KITTITAS COUNTY COMMUNITY DEVELOPMENT SERVICES

Subject: Suncadia Ph 3. Div. 14 (LPF-18-00007) Final Plat – Staff Review and Request for Additional Information

Kittitas County Community Development Services (CDS) received your Suncadia Ph. 3 Div. 14 (LPF-18-00007) Final Plat submittal on September 27, 2018. Final plats must be processed and approved by BOCC within 30 days of the submittal date. Kittitas County staff have completed the review of your final plat submittal. As provided below, staff has the following comments, requirements, and/or revisions for your application that need to be addressed prior to final approval and signature of the final plat mylars:

DATE: 2018-09-26 JOB NO. 998-767-017-0100
DRAWN BY: C.A.F./R.F.G. SHEET 1 OF 5

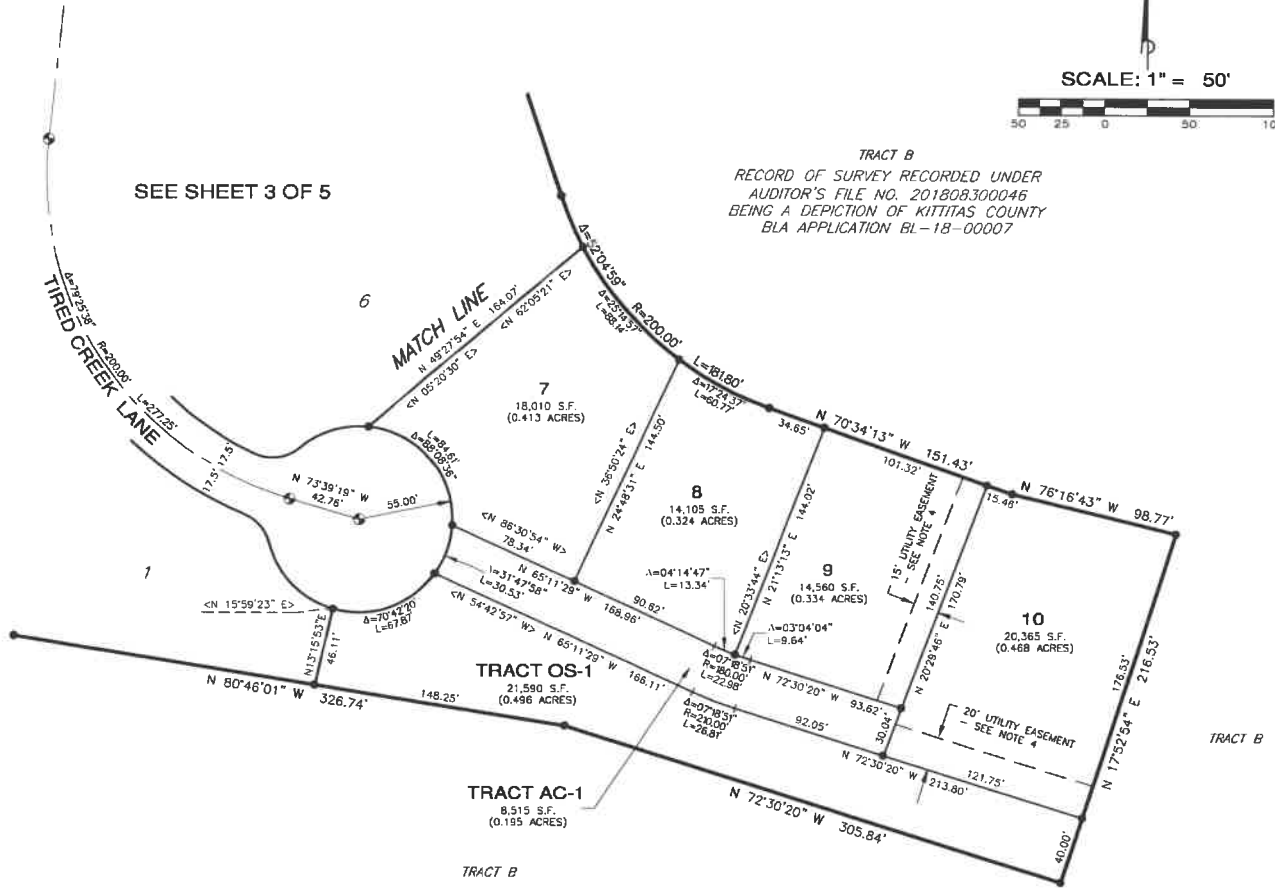
- **Required Changes**
 1. On sheet 1 the Recording Certificate is shown in two locations.
 2. Sheets 3 and 4 are missing the surveyor stamp.
 3. Please check the bearings and distances as shown on the access road North of Lots 3 and 4. If I retrace the access road from the N'most corner of Lot 3, I am unable to close on the NW corner of Lot 4.

PP-01

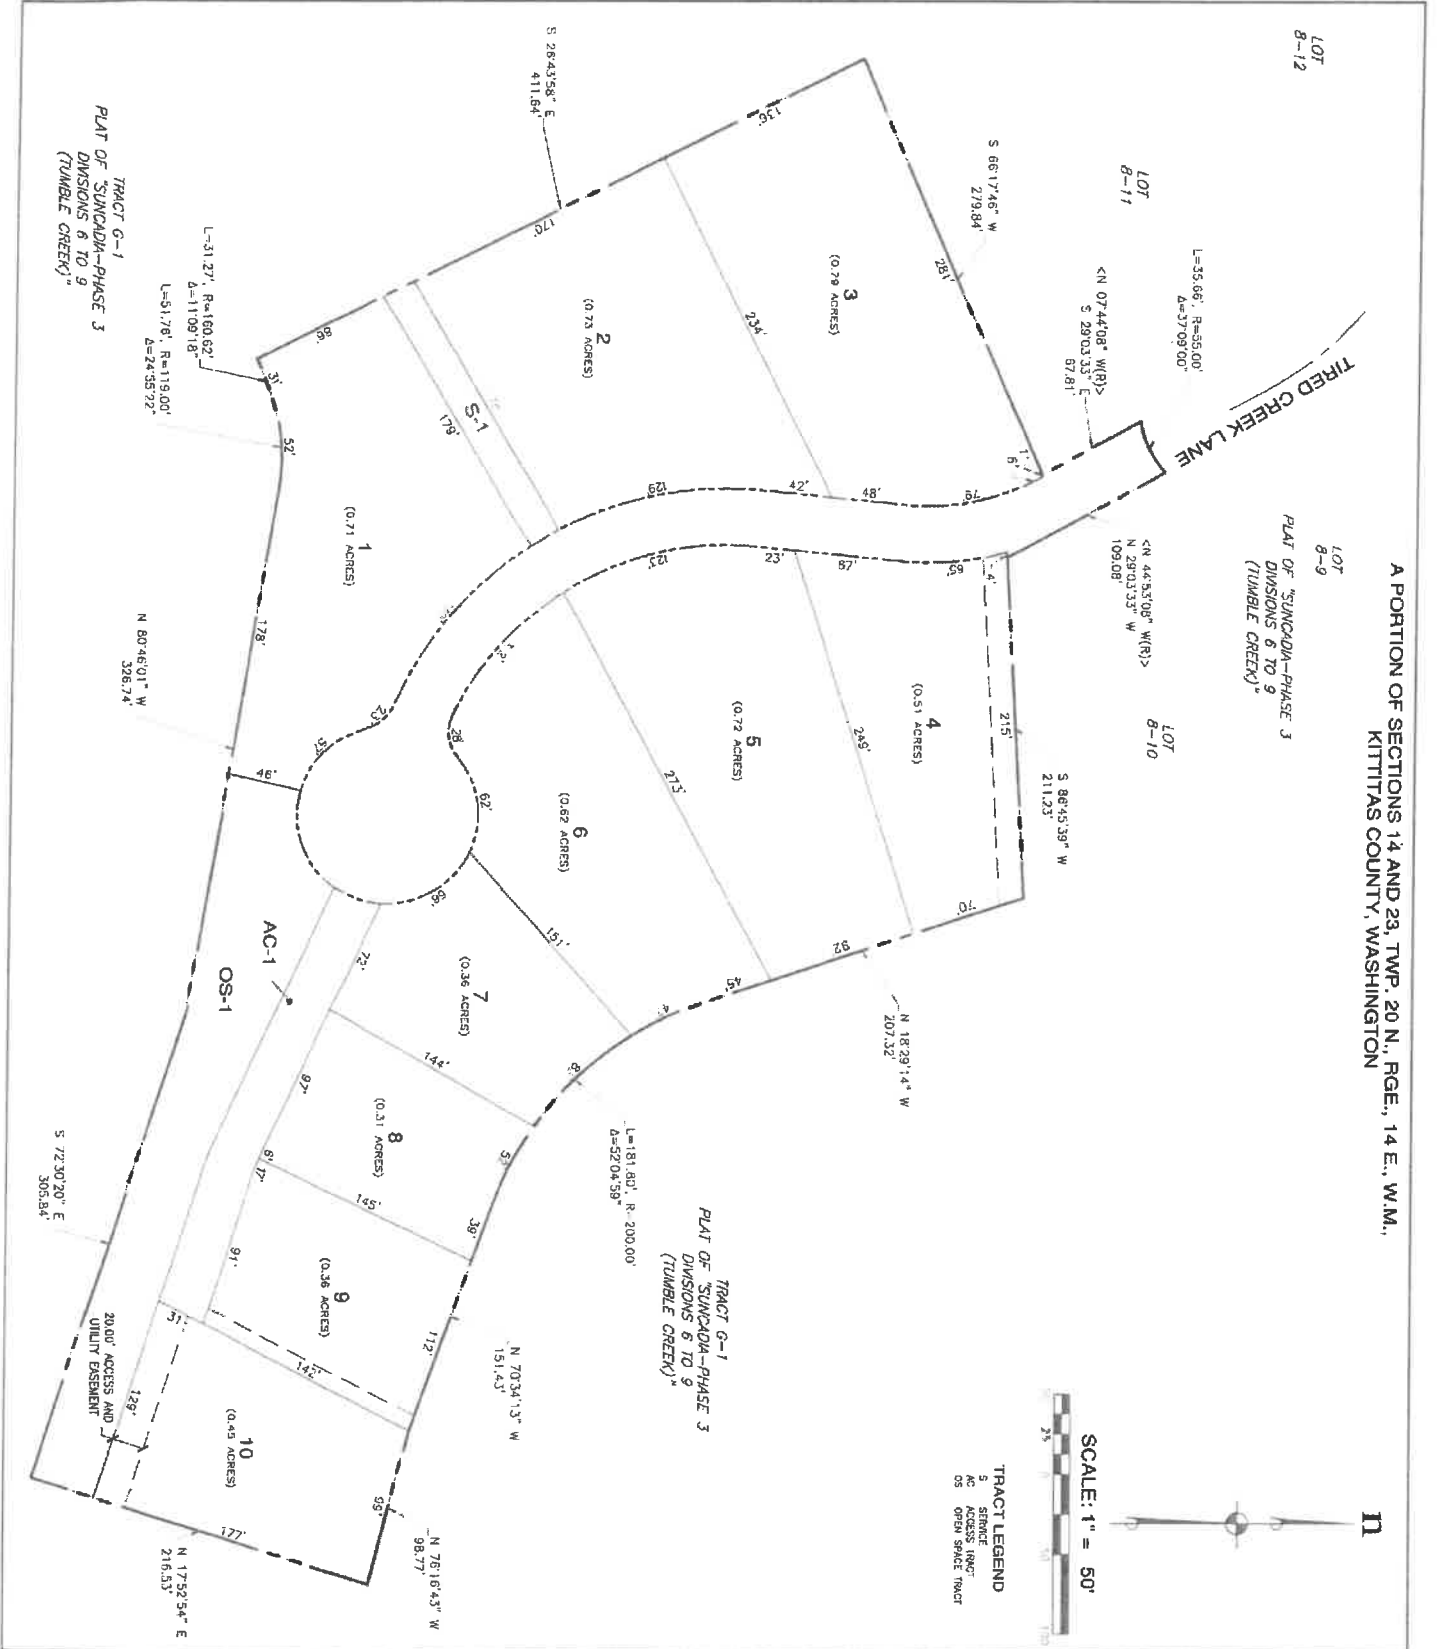
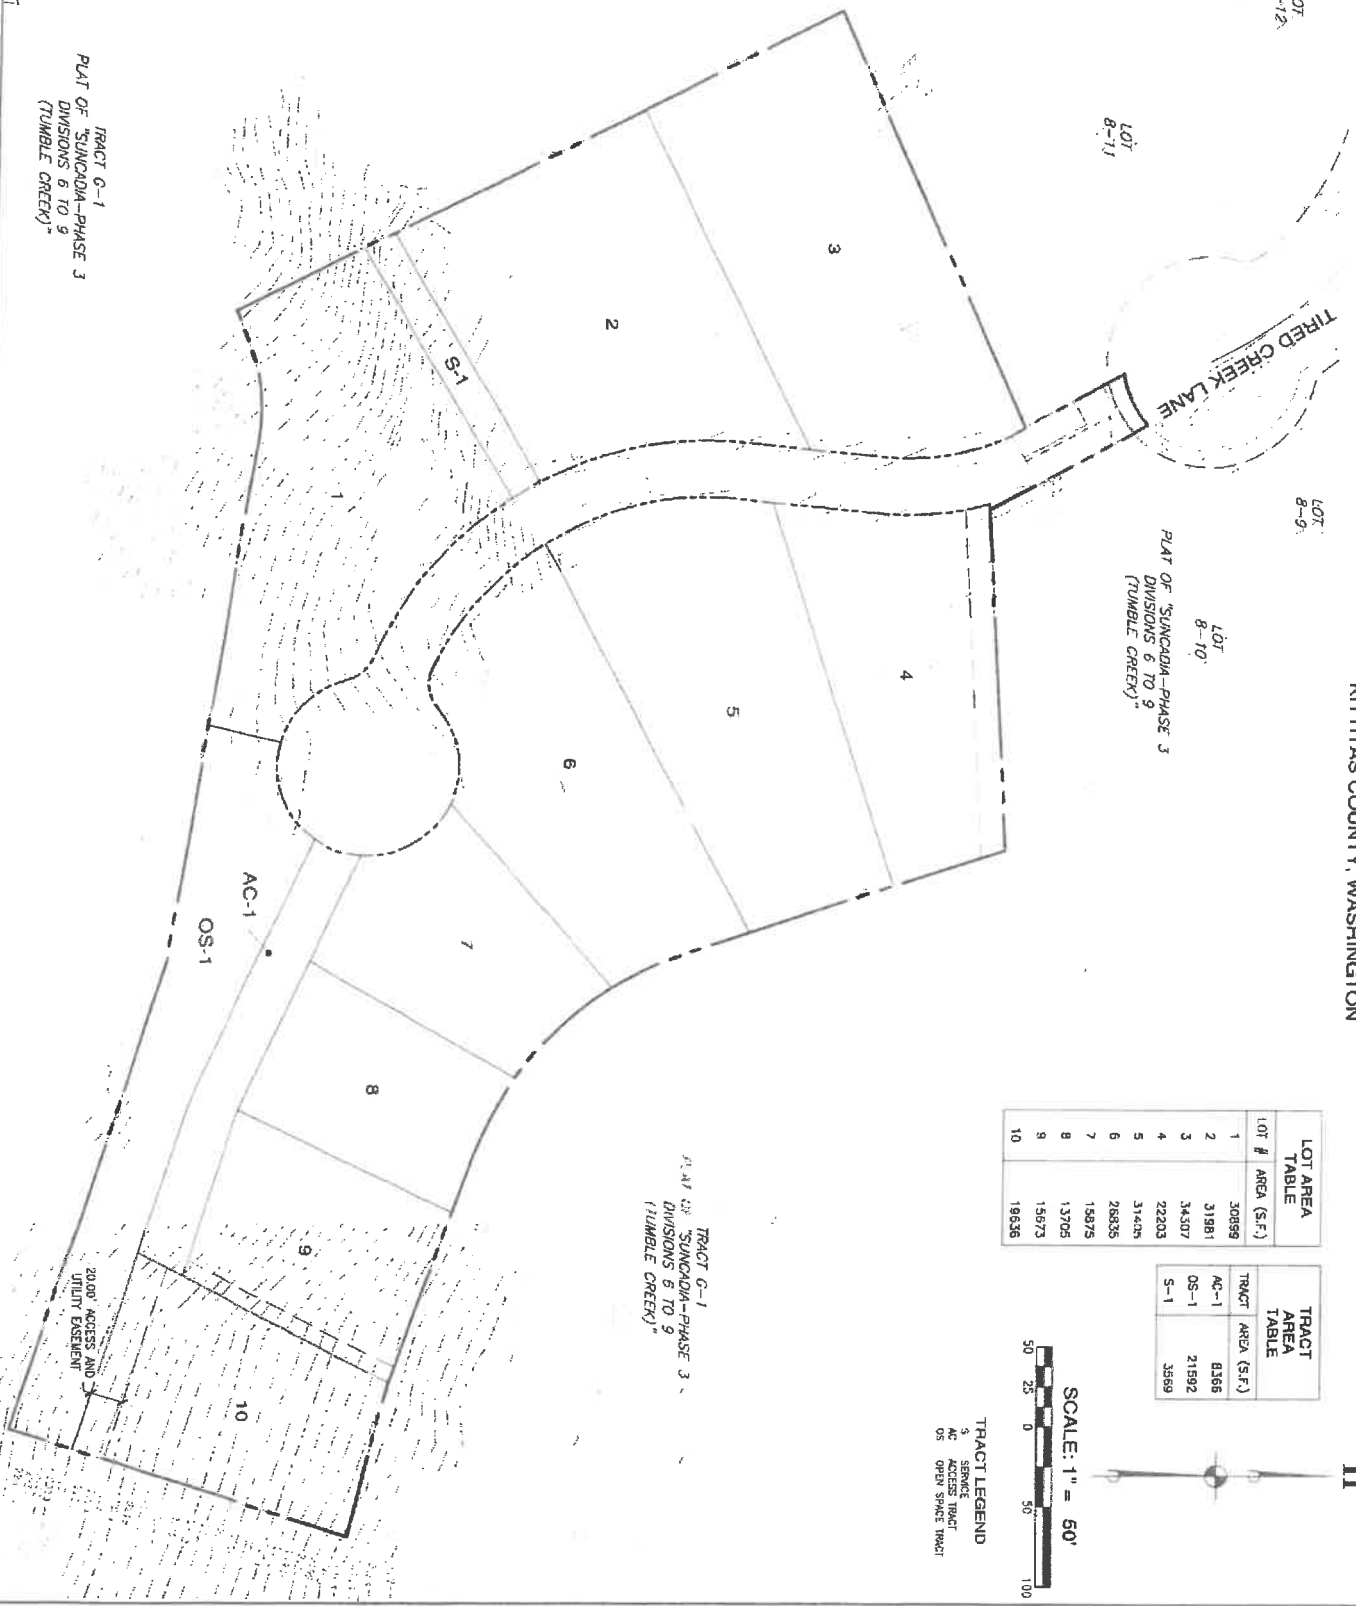
1. Pursuant to KCC 16.20.020(1), please provide final plat drawings on mylar/polyester film for routing and signature.
2. Pursuant to Resolution number 2018-132, #11 ; The lot areas tables must be amended to show on the final plat; S-1, AG-1, and OC-1. Staff could only locate S-1. AG-1 and OC-1 must be added to the lot area tables for final approval.
